WELWYN HATFIELD COUNCIL – DEVELOPMENT CONTROL
DELEGATED REPORT

APPLICATION No:	S6/2010/2999/FP
------------------------	------------------------

The proposal is to create a single storey rear extension to be used as a dining area with a pitched roof above comprising of five rooflights, a first floor side extension to be used as a bedroom and ensuite and a single storey front/side extension comprising of a garage, storage and new entrance hall. The existing loft space along with the roofspace created for the first floor side extension will be converted into a studio/playroom with two rooflights on the rear elevation and one rooflight on both the side and front elevations.

sara a rattenbury
architectural design consultancy
tel/fax 01727 752170 mob 07812828429
TITLE
PROPOSED
ELEVATIONS
ADDRESS
97 BRAMBLE ROAD
HATFIELD, HERTS AL10 9SB
CLIENT
Mr. & Mrs KIFF
SCALE
1:100 @A3
DRAWING No.
BR102-5
DATE
DEC 2010
REV.
-

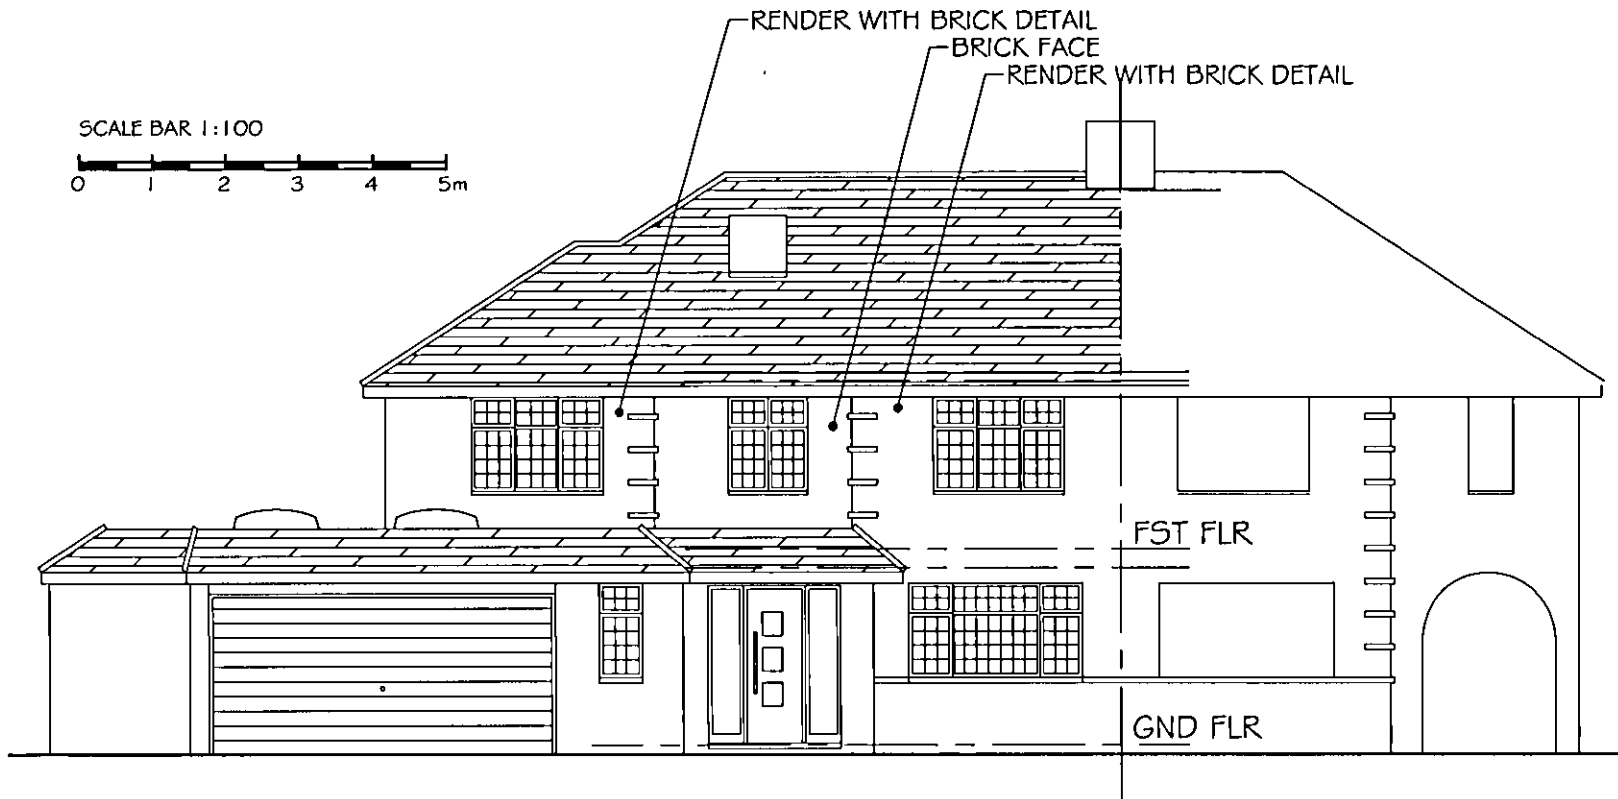
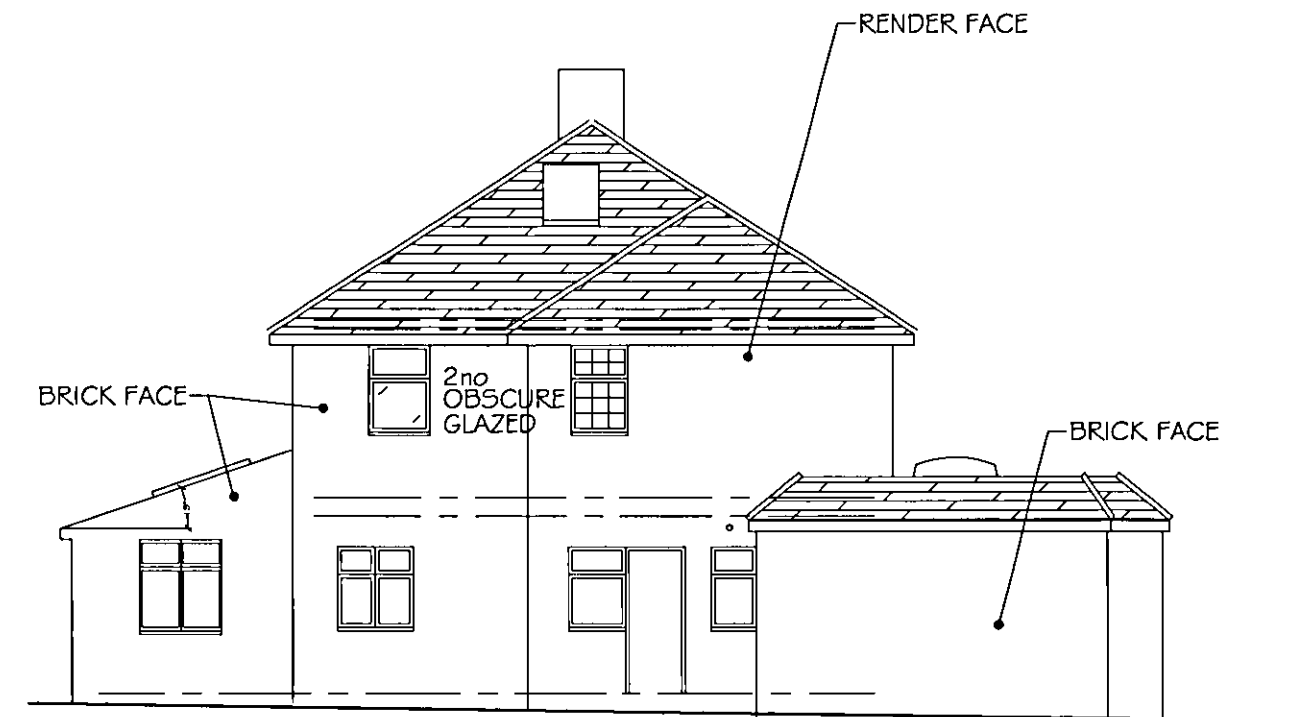
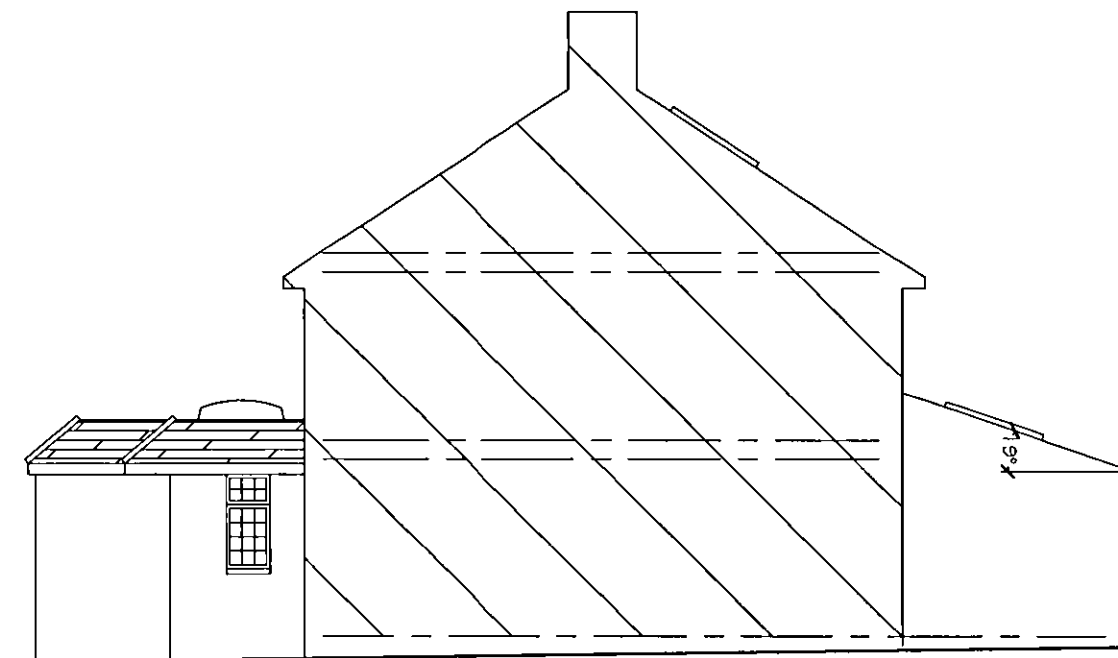
This area of Bramble Road comprises mainly of semi detached properties which are set back from the main road. Whilst a number of properties have incorporated small front extensions, the built form of development along Bramble Road generally remains in line with each other. The proposed single storey 'wrap around' extension to the front and side extends out beyond the front elevation of the existing dwellinghouse by 3.8 metres with the maximum width measuring 11.7 metres. This proposed bulk of development to the front of the dwelling would be considered prominent within the streetscene taking into consideration the consistency of the built form of development within the locality. The proposed front extension therefore fails to comply with policy D1 of the Welwyn Hatfield District Plan, 2005.

The proposed first floor side extension measures a total of 6.8 metres in height. The ridgeline is set 0.9 metres below the ridgeline of the existing roof. Policy D1 and the supplementary design guidance, paragraph 5.2 (v) states, 'for all multi-storey, two-storey and first floor side extensions, a minimum distance of 1m between the extension and the adjoining flank boundary must be maintained. This spacing is to prevent over development across plot widths and a terracing effect within areas of detached and semi-detached properties'. The proposed first floor element of the extension maintains a 1 metre separation space. Other properties within the vicinity of No.97 have incorporated a first floor side extension. The proposal at No.97 does not detract from the design and character of the surrounding area at first floor level and therefore complies with policy D1 and D2 of the Welwyn Hatfield District Plan, 2005

The proposed single storey rear extension extends beyond the rear wall by 3 metres. The neighbouring property, No. 99 Bramble Road already has a single storey rear extension with a flat roof. The proposed pitched roof rear extension measures the same depth as that at No. 99 and therefore is not considered to impact on the amenity of No.99.

On the eastern side elevation of the proposed single storey rear extension is a window which is not shown to be obscure glazed. Taking into consideration the existing boundary treatment, the proposed window on the side elevation is considered to exacerbate the sense of overlooking to the neighbouring property. In addition, the window is not considered necessary for the purposes of sunlight/daylight to the rear extension as it is south facing and the rear elevation comprises of a large five panel bi-folding patio door with a window either side and five rooflights within the pitched roof. The new window proposed on the side elevation of the existing dwellinghouse which would form part of the new kitchen could be conditioned to be obscure glazed. The two windows proposed on the first floor side elevation of the dwellinghouse are shown to be obscure glazed. The proposed first floor side extension maintains a 1 metre separation space at its closest point to the boundary and measures approximately 7 metres from the flank wall of No.95. The proposed first floor extension is therefore not considered to impact on the amenity of adjoining neighbours.

The eastern side elevation of the single storey front extension forms the boundary with No.95. No. 95 has a detached garage on its side elevation however its remains set within the site and does not protrude forward from the front elevation of the main dwellinghouse. Taking into consideration the bend in the road, the proposed front extension would appear prominent from the adjoining neighbour, No.95. However, the prominence of the extension is not considered to be detrimental to the amenity of the adjoining property taking into consideration it is single storey and measures some 9.5 metres from the flank wall of main dwellinghouse of No.95.

The depth and bulk of the proposed front extension would be prominent within the streetscene taking into consideration the overall consistency of the built form of development within the locality. The proposed front extension therefore fails to comply with policy D1 of the Welwyn Hatfield District Plan, 2005 and PPS1: Delivering Sustainable Development.
